### Section 75W Amendment to MP10\_0016 - Scottish Hospital Paddington

This letter constitutes a request to amend the Project Approval for MP10\_0016 (Scottish Hospital Paddington) issued in May 2012 under the former Part 3A of the Environmental Planning (EP&A) Act 1979, and is prepared on behalf of Brookfield Multiplex Constructions Pty Ltd. The application is made in respect to land at 2 Cooper Street Paddington, legally described as Lot 2 DP 607572.

Modification is sought to the approval in respect to eight (8) elements. Each is addressed separately below. Supporting documentation in respect to each of the modifications is provided with this application and is listed against each item for ease of reference.

DA drawings showing extent of metal roofs

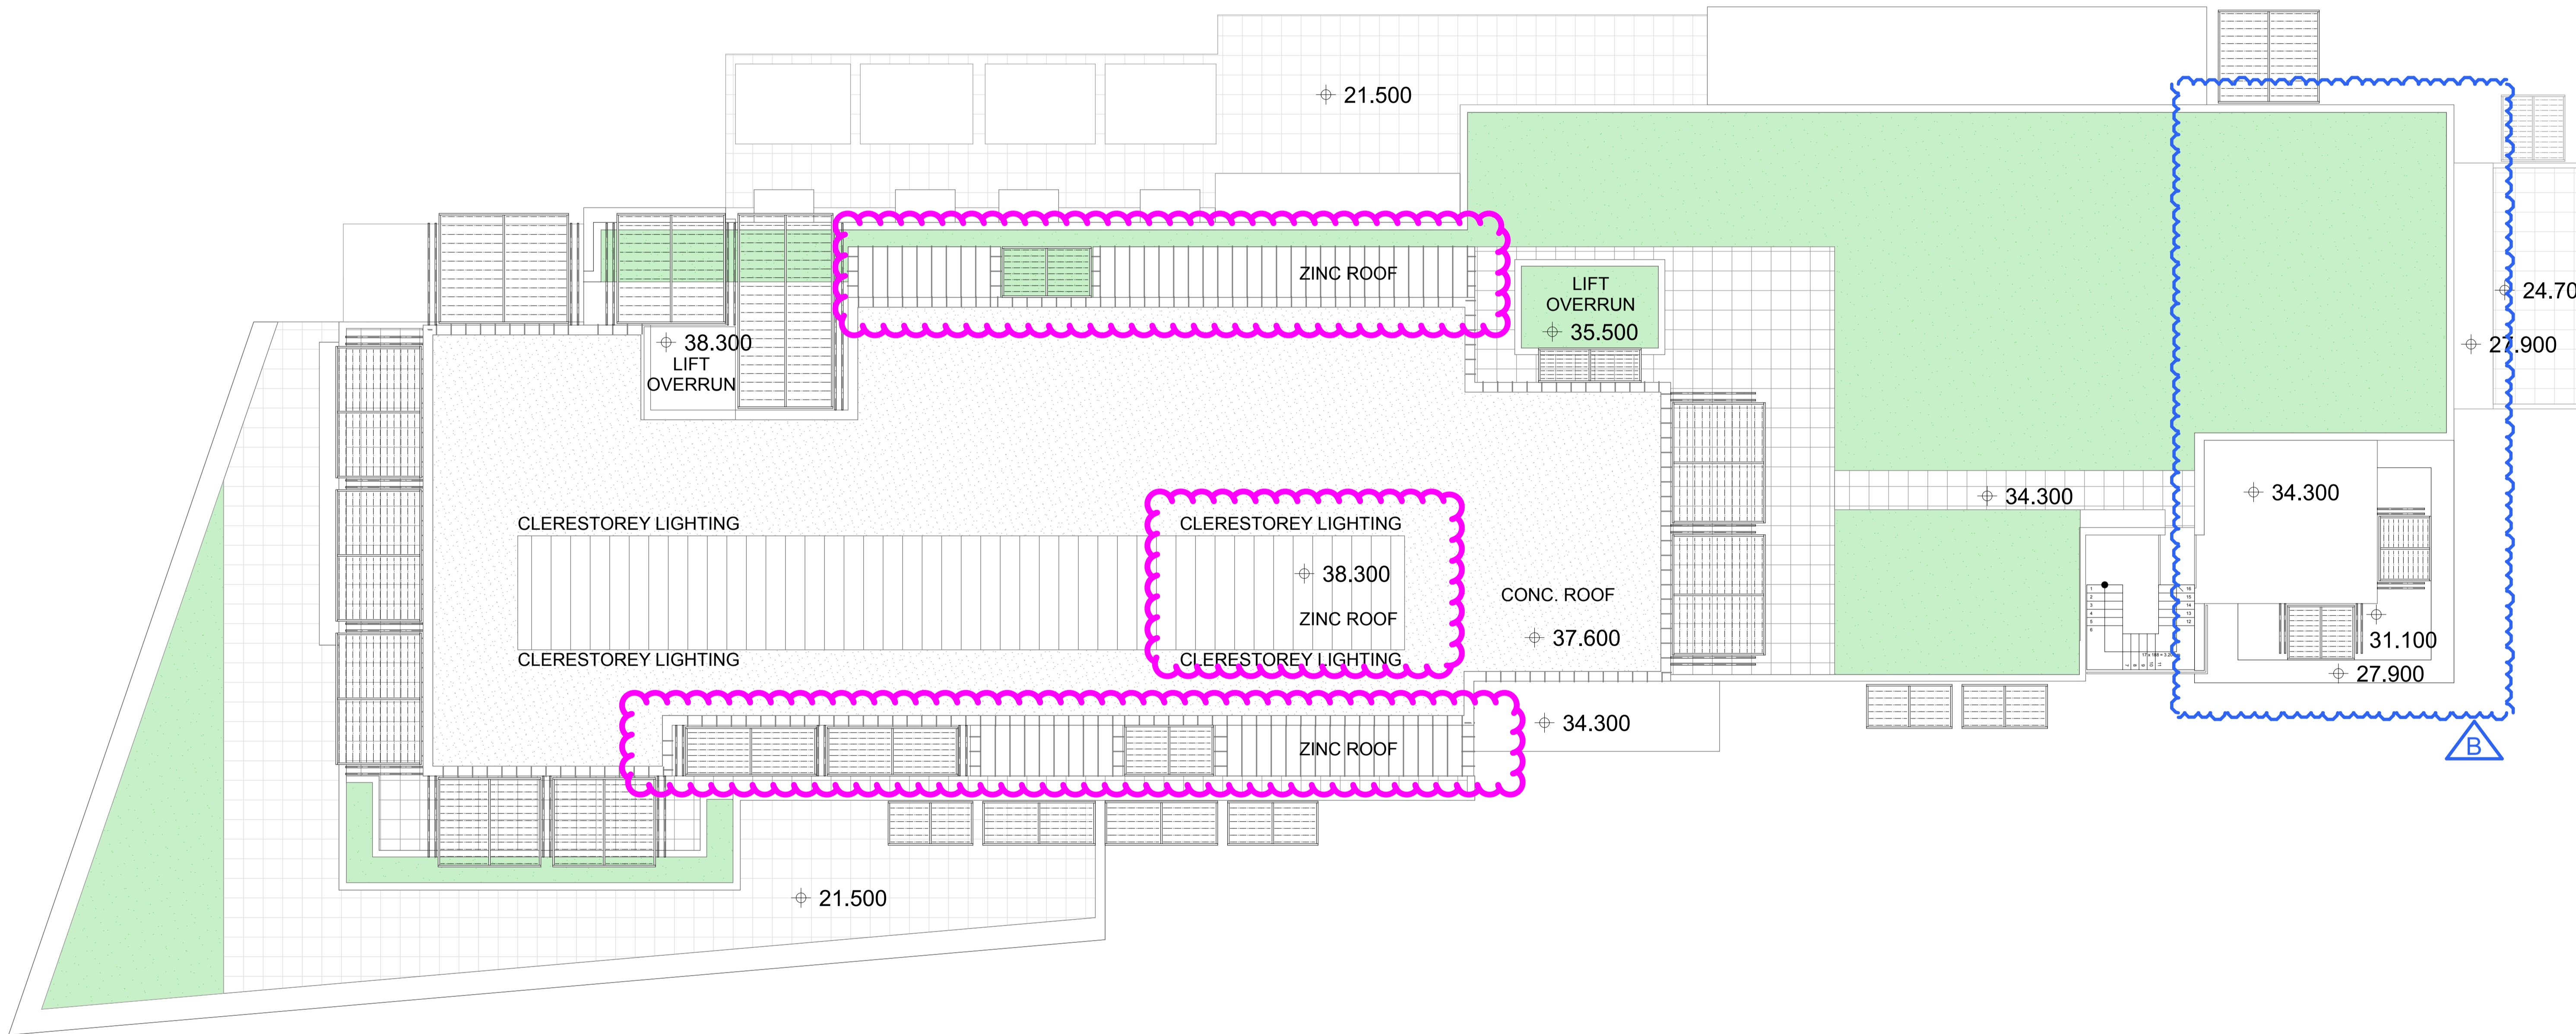
It is proposed that the approved metal roof for both the Brown Street ILU and Stephen Street RACF/ILU building be replaced with concrete slab. The return fascias on the building elevations will remain clad in metal to maintain the appearance of a metal roof when viewed from the public domain.

The change in material is required for improved material longevity due to the site's proximity to the salt water body of Sydney Harbour, acoustic performance and thermal performance. It will also ensure ease of access to the roof for maintenance reasons.

West RACF Elevation  
1:100

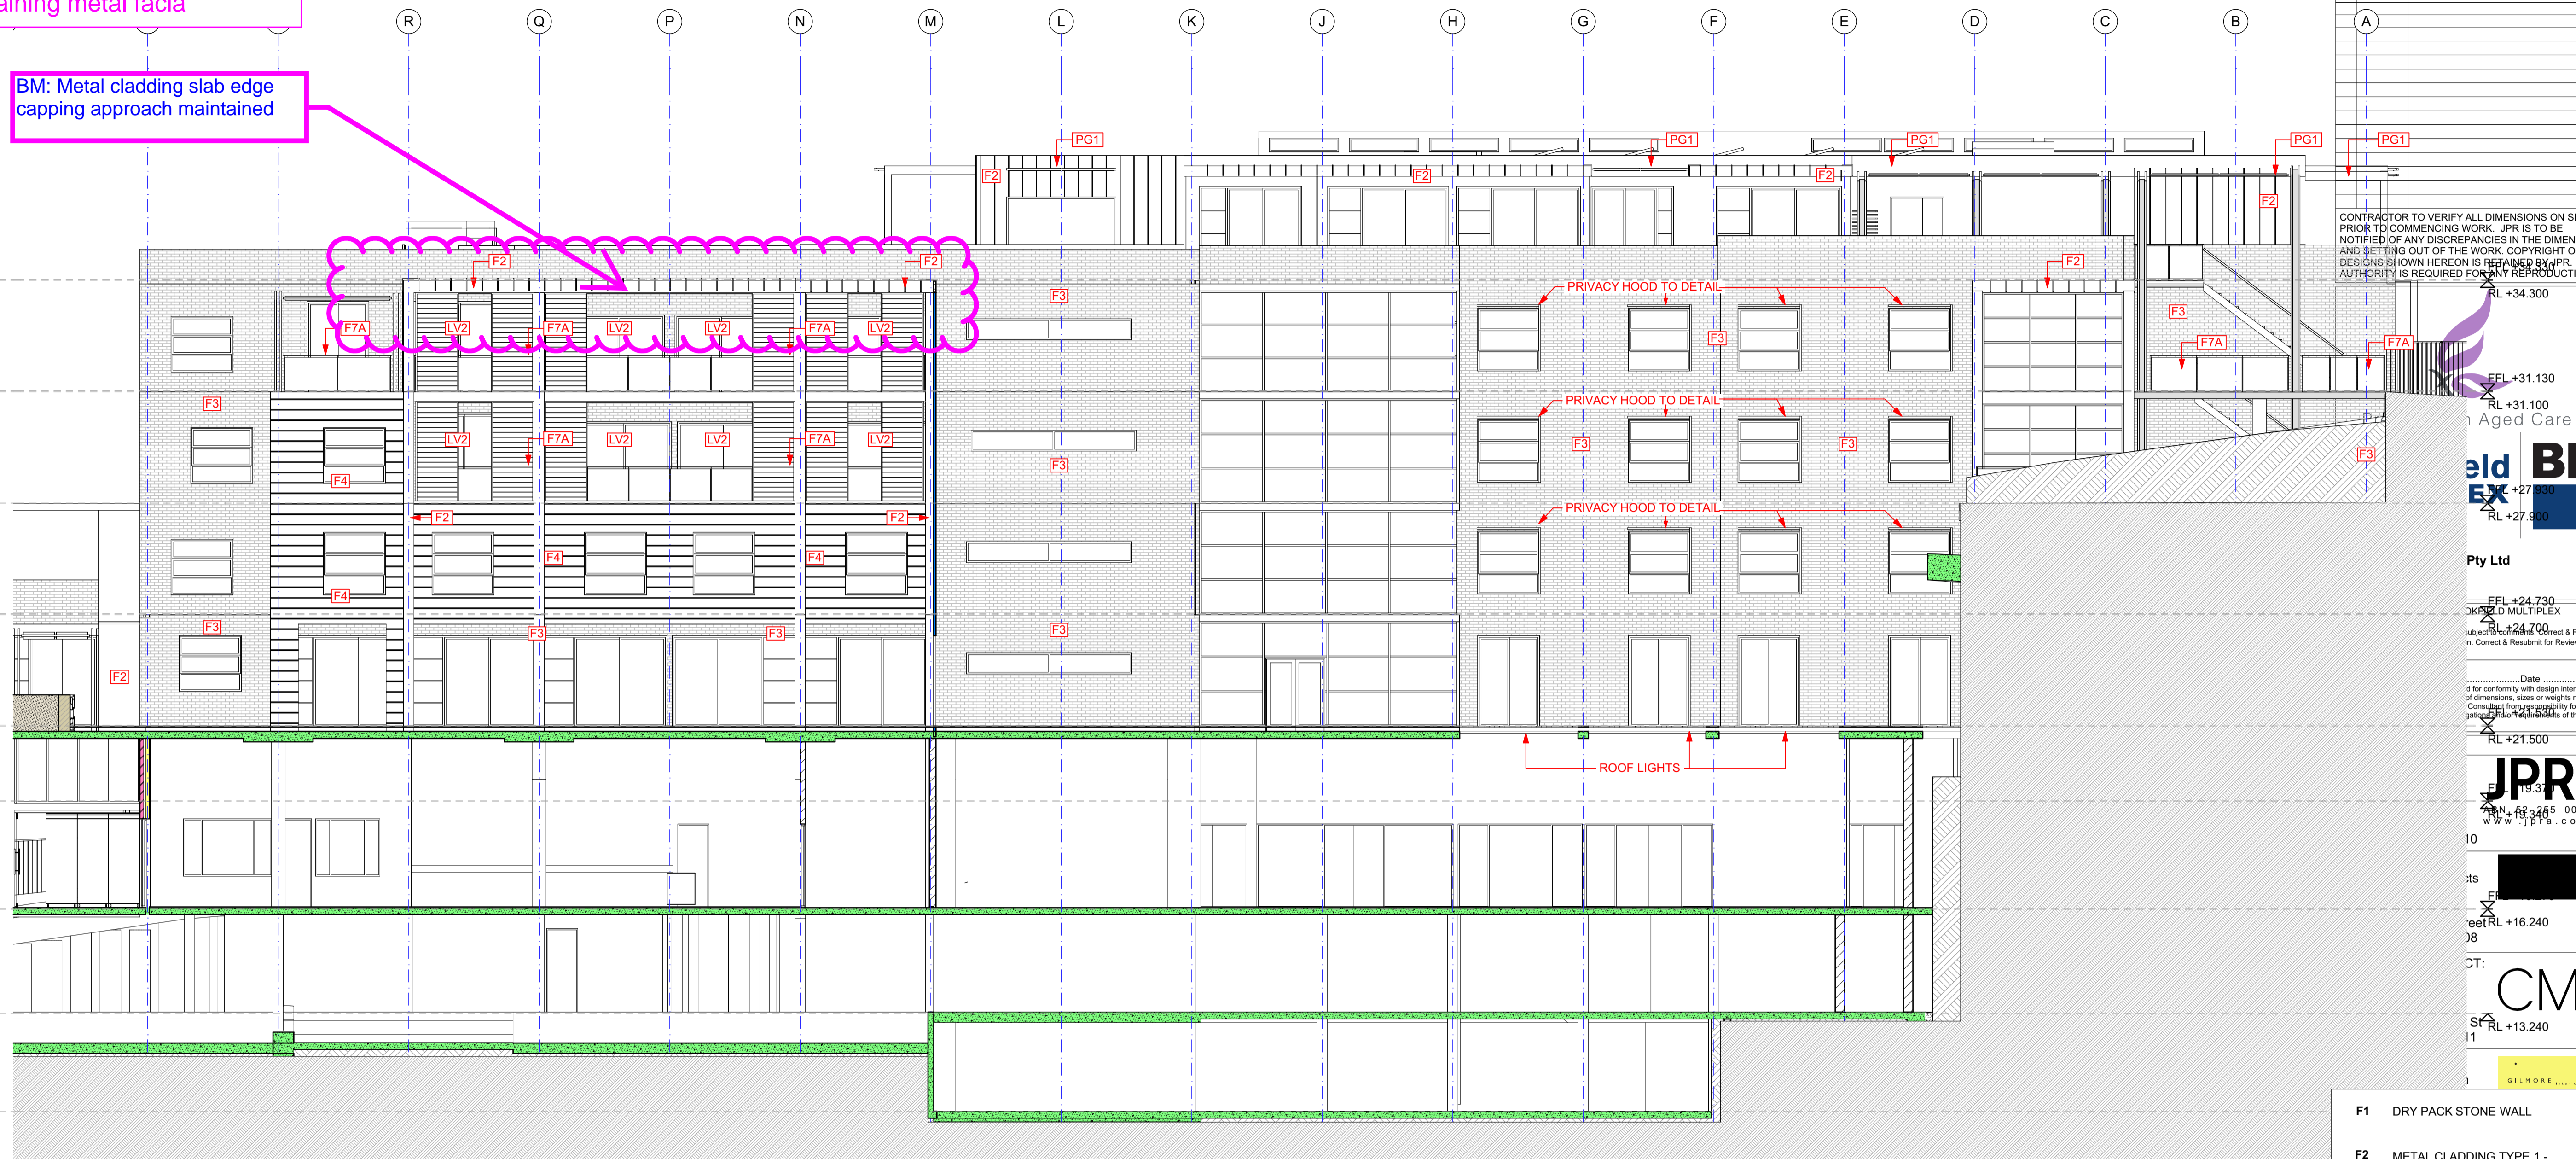
No change to building appearance will result from the public domain due to the retention of metal fascias on the building elevations.
